Your ref: SSD 7198
Our Ref: 0820732

**SSD 7198 – Moonee Beach Residential Subdivision
Interim Response to RFI issued 15 July 2019**

Attachment A
Revised Subdivision Plans – Civiltech

Scale Horizontal 1:100 Vertical 1:100

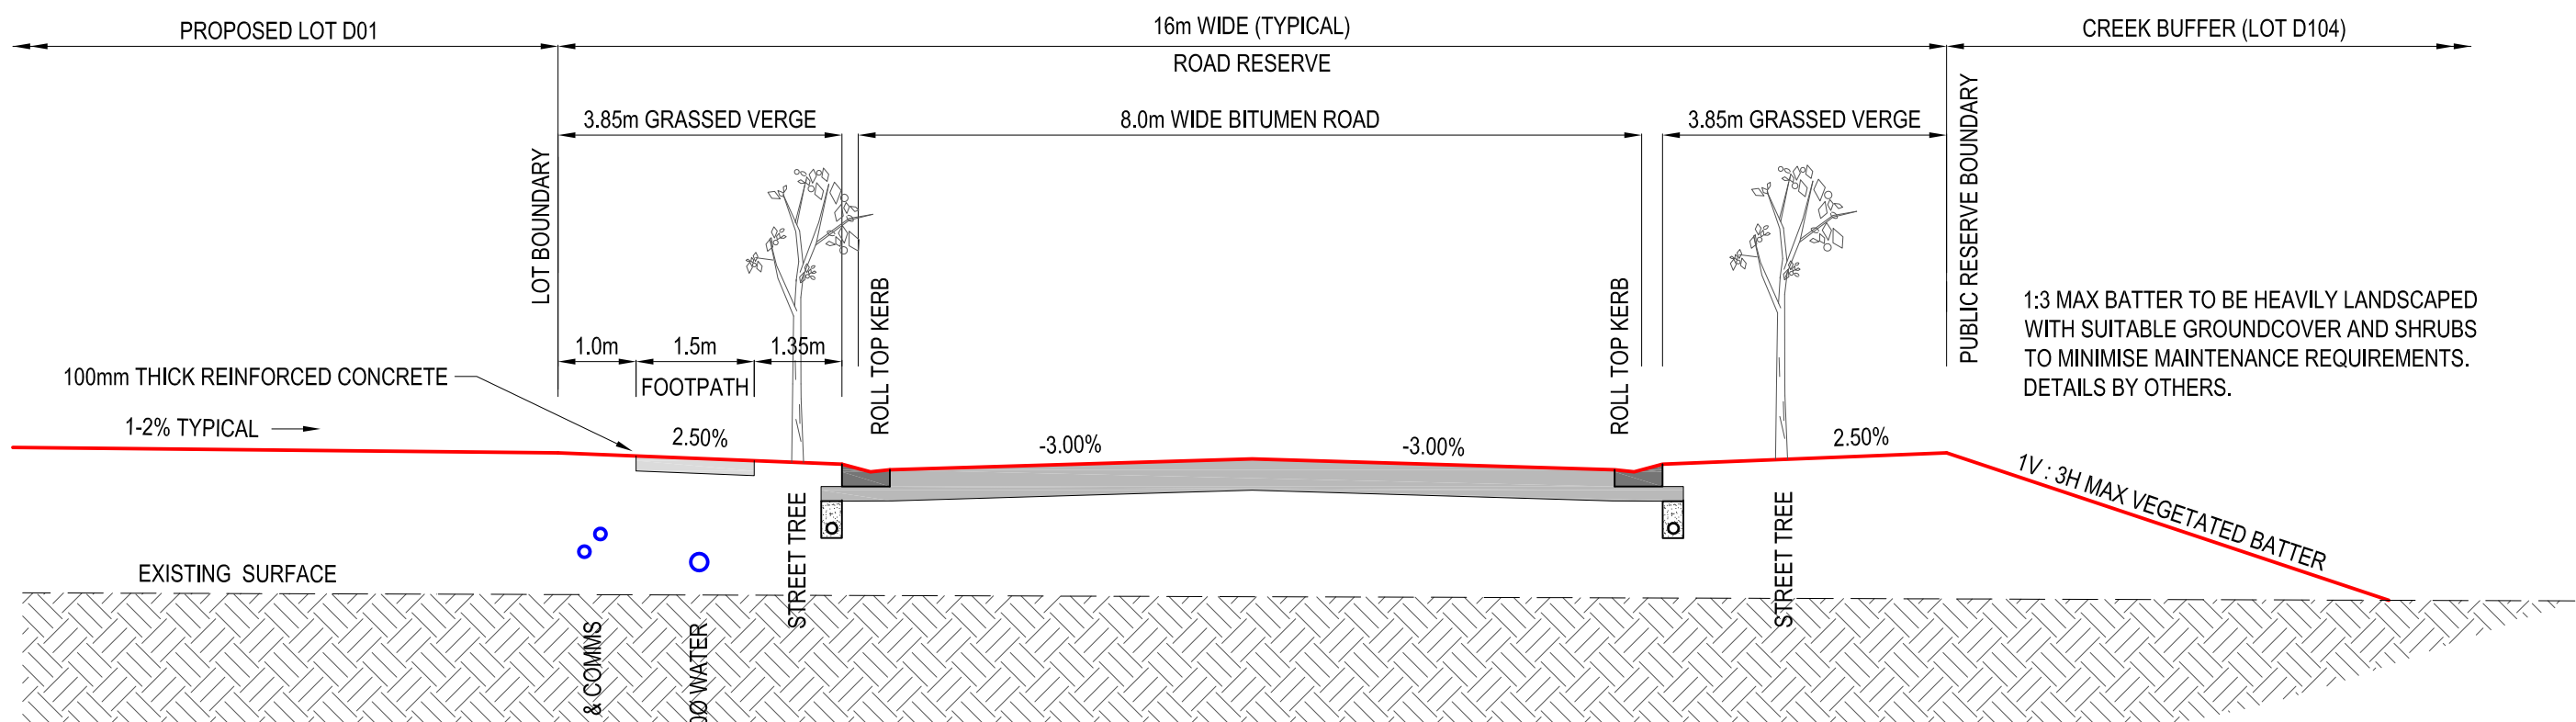
Further evidence is required demonstrating that the road reserves are capable of complying with Council's requirements, including infrastructure and street trees being accommodated.

The CHCC Development Design – Geometric road layout sets road geometry requirements for a range of road types. Roads 2, 6 & 7 are classified as Local streets with vehicle movements up to 2,000 vpd. They are required to be 8m wide with minimum 4m verges. Roads 4 & 5 are classified as access streets and require to have a width of 5.5-7.0m. The proposed roads 4 & 5 are 6.5m wide in a 14m verge. Additional details of service allocations have been added to the plans.
